**Project:** 2715 Ashe Ave.  
**Location:** Dunn, NC  
**Company:** STE General Contractors  
**Care Of:** Shane McLeod  
**Subject:** Rebar Omission  
**Job Number:** 2-2754-24

We have reviewed the structural plans for the proposed build - Plan Name: BB-2282R ; Designed by "House Plan Zone".

SHEET NUMBER
2

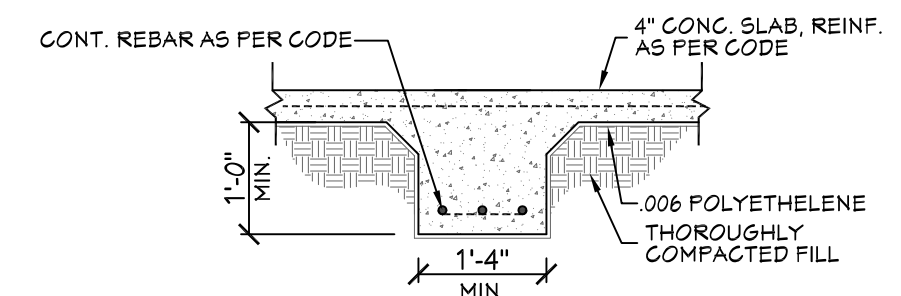
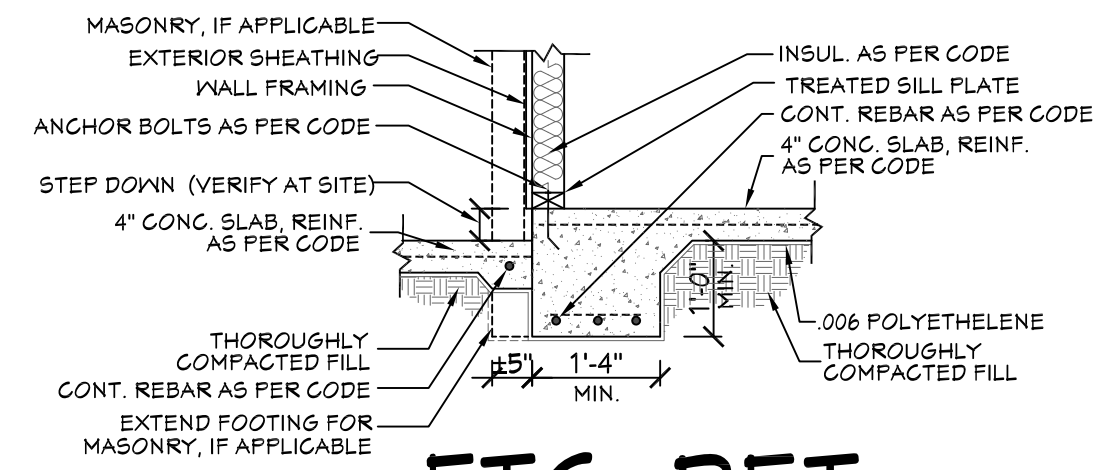
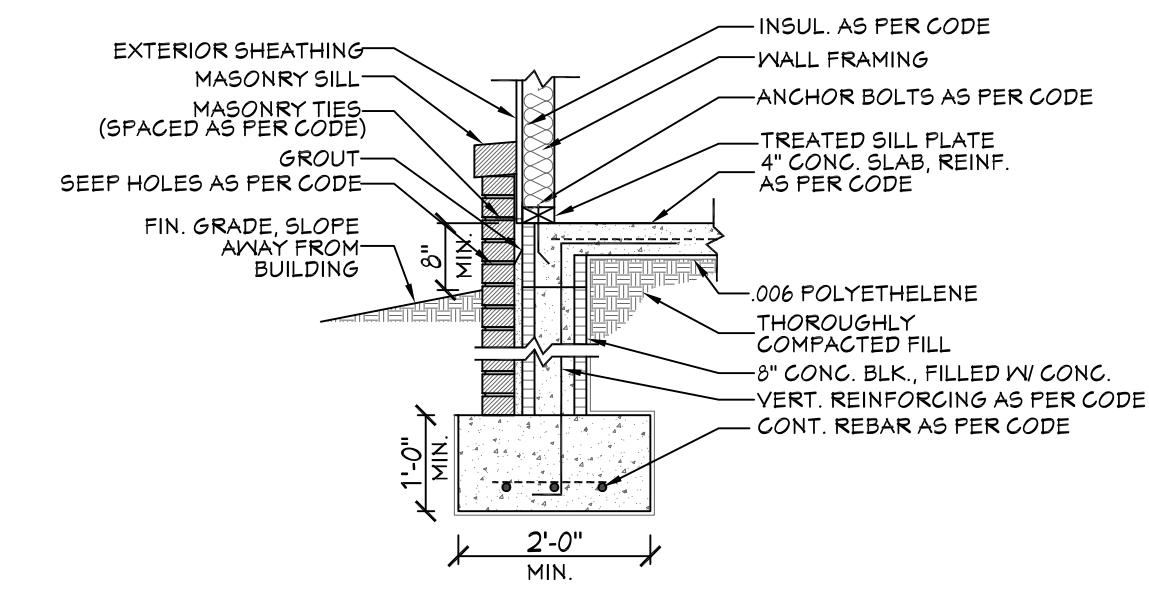
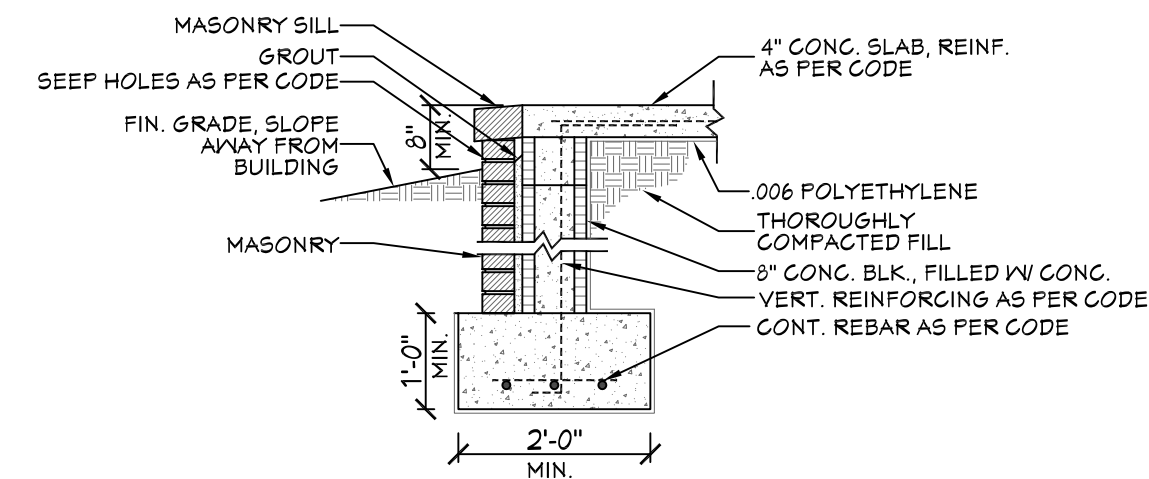
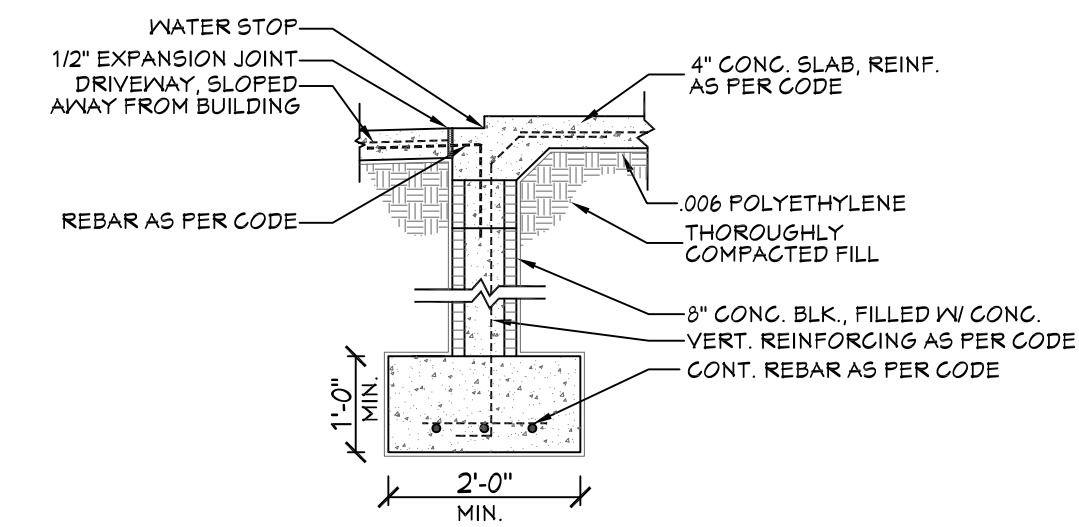
On sheet 2, details 203, 205, 220, 221 and 223 all note steel reinforcement in the footing detail.

**Based on review, provided the soil quality is found suitable and firm (no less than 2000 PSF) the per plans rebar may be deemed optional (IE not required by code nor calculations).**

1- We do however strongly recommend the use of welded wire fabric and/or fiber reinforcement in the slab.

2- **Where unbalanced conditions of the foundation wall (IE distance between top of slab and grade) meet or exceed 36"; we recommend the installation of vertical rebar within the footings, stem wall, and slab. Specifically, we recommend**

A - (2) continuous #4 rebar in footings.

B - Vertical rebar with a 6" hook into footings, and 24" spline into the slab. Rebar shall be #4 spaced at 32" (for 3' to 4' unbalanced) and 24" (for 4'-5' unbalanced).

**These reinforcement need only be installed at areas of greater unbalanced fill (if any). All stem walls shall be filled solid with grout or concrete regardless of unbalanced height.**
